Application No: R/102/20/PL
Site Address: Land north of Springfield house Cross Road Rustington BN16 2ST
Description of works: 1 No. detached 5-bedroom house with attached single storey double garage & carport.

Thank you for your internet representation made on 21st July 2020 which has been recorded as an objection with the comments as follows:

Planning Application Ref: R/102/20/PL
Land North of the Spires, Cross Road, Rustington

Project Title and Location	
Land to the Rear of The Spires, East Preston	
Client	
Mr M. Osborne-Shaw	
Drawing Title	
Tree Constraints Plan	
Scale	Drawn
1:250@A1	LB
	Approved
	GS
Date	27.05.20
Revision	
00	
Drawing No	
LLD1935-ARB-DWG-001	
CAD Filename	
LLD1935-CAD-ARB

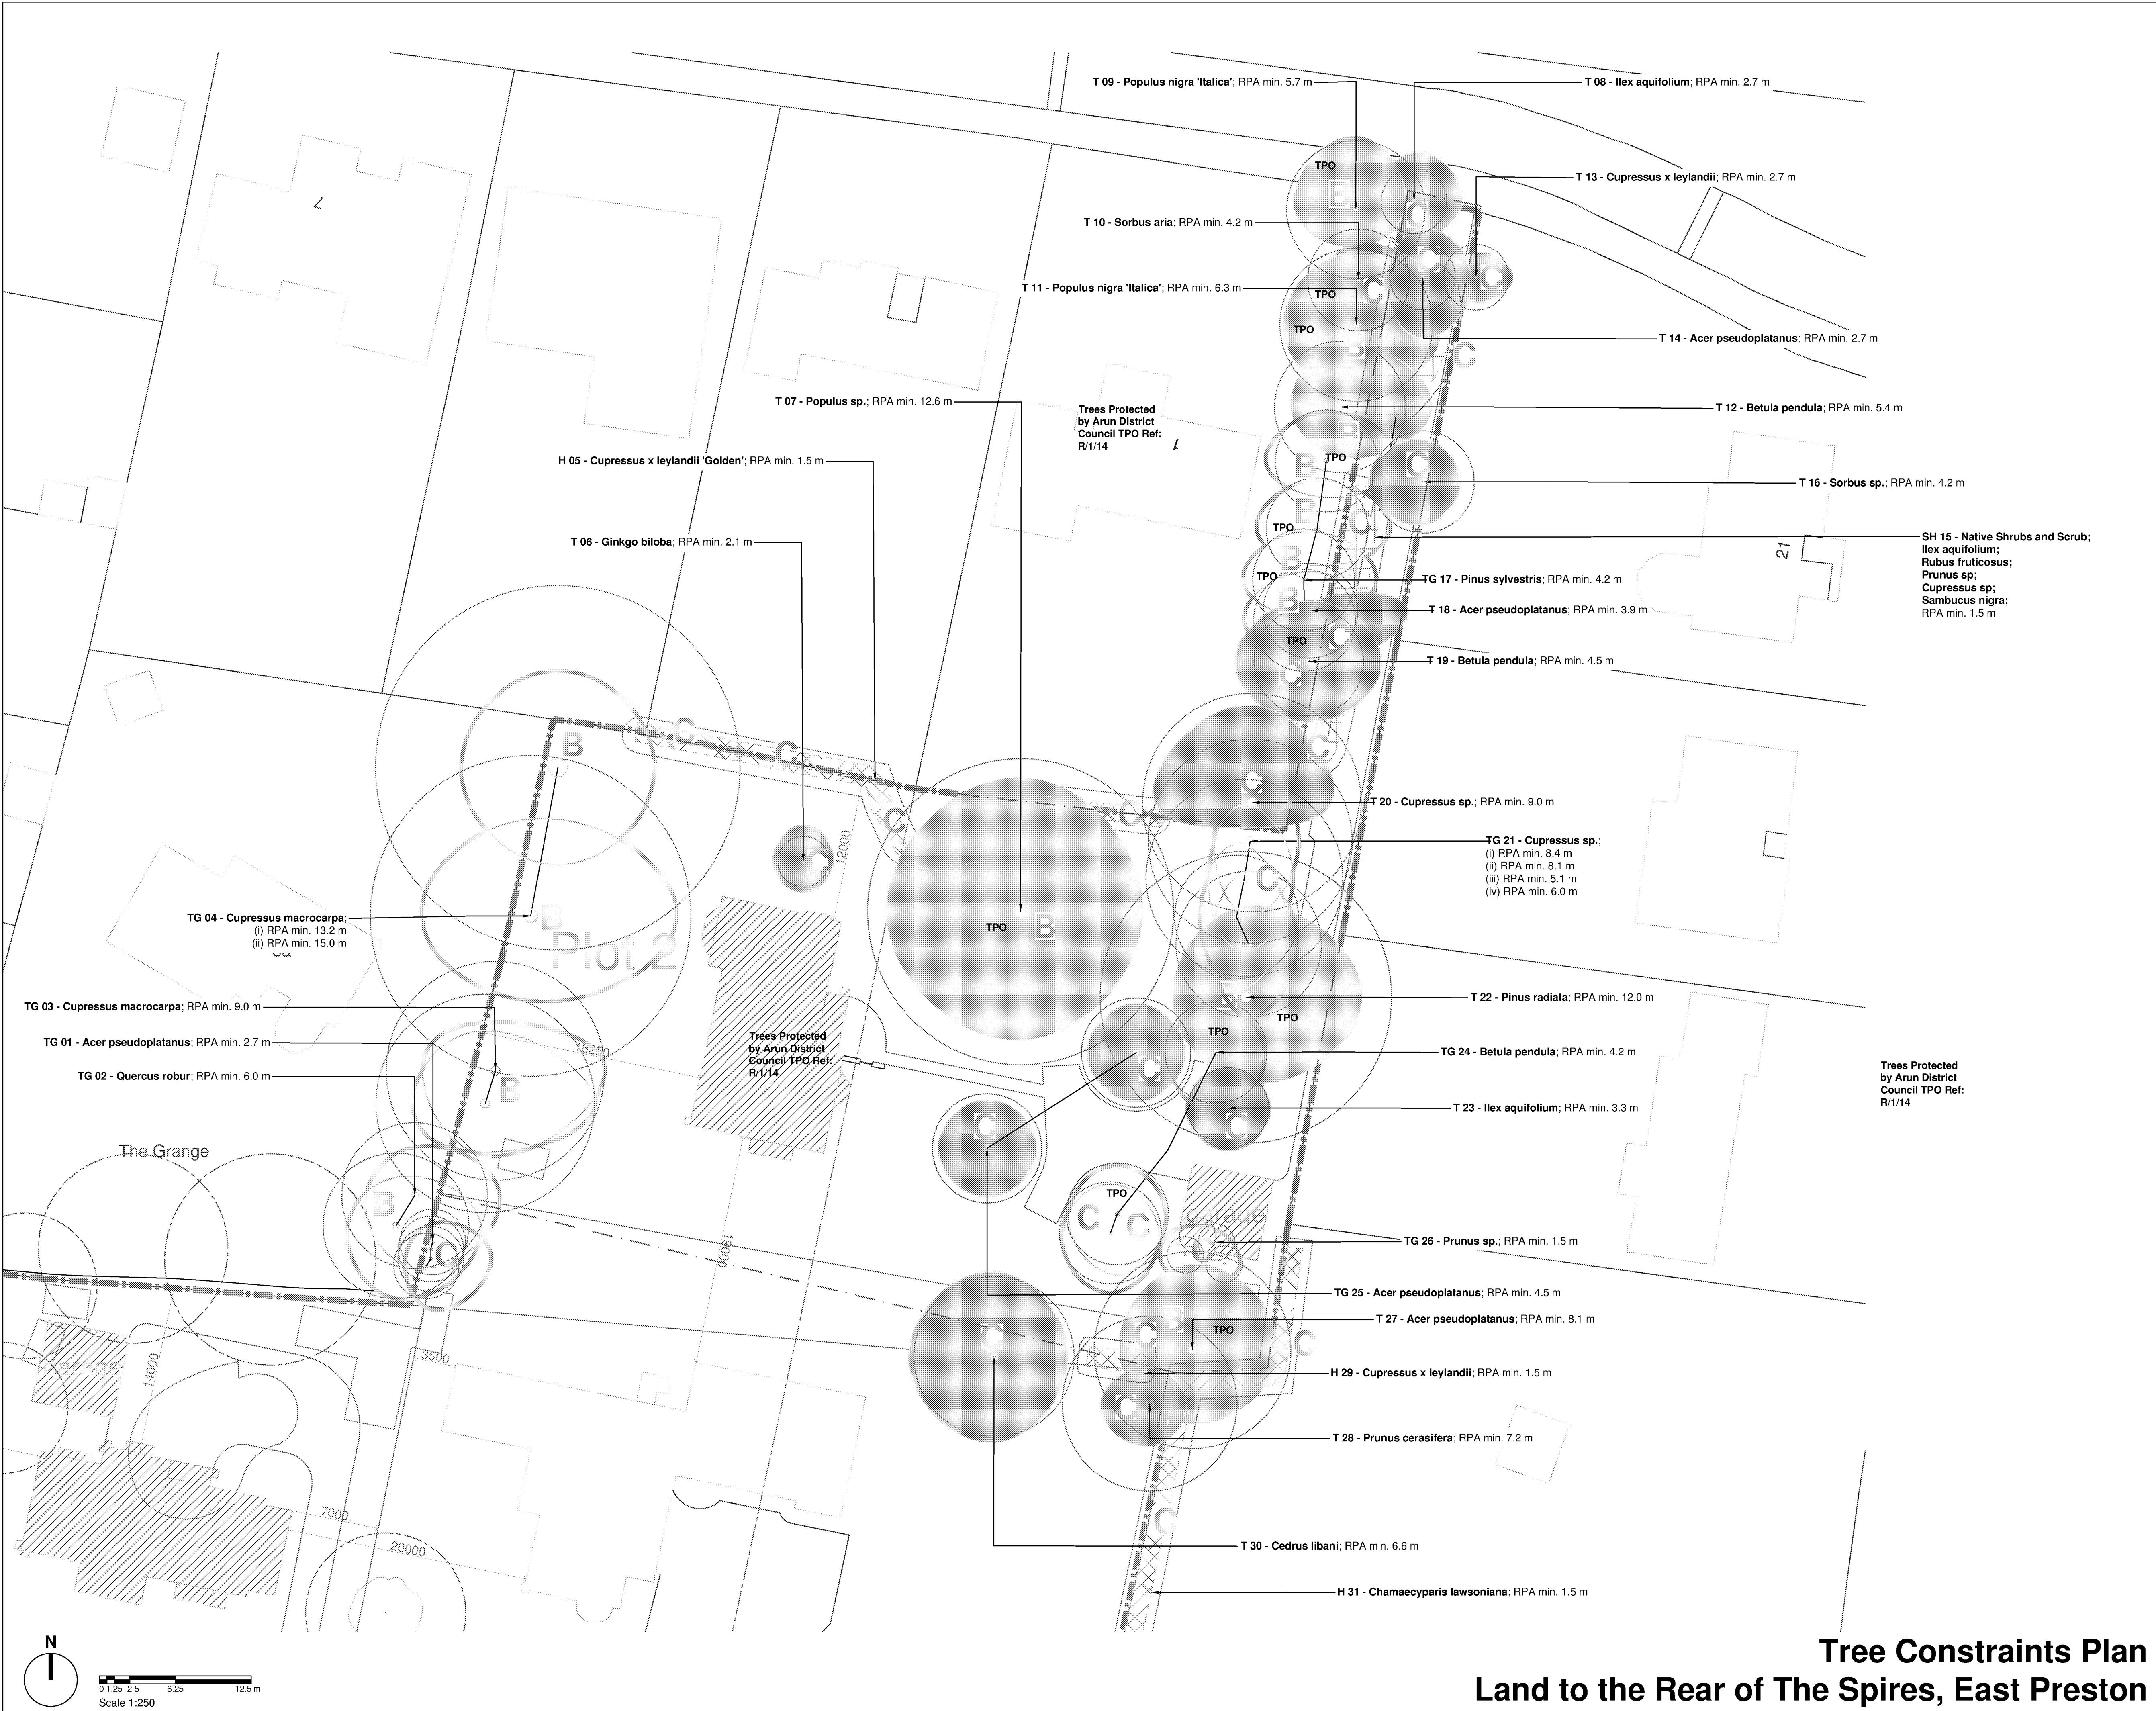
The mature macrocarpas referred to as TG03 and TG04 are stated as being retained. Although referred to in the plans as being trees of moderate quality and value, I believe that they are a central feature of the interior of the Cross Road/Angmering Lane/Springfield Close/Pigeonhouse Lane quadrangle and contribute greatly to the woodland character and visual amenity of the whole area. They also provide wind shelter and privacy to numerous surrounding properties and are clearly visible from surrounding roads. Other visually significant

macrocarpas in the area (eg at 2 Botany Close) have been protected and I believe that a planning condition should be set for the retention of TG03 and TG04.
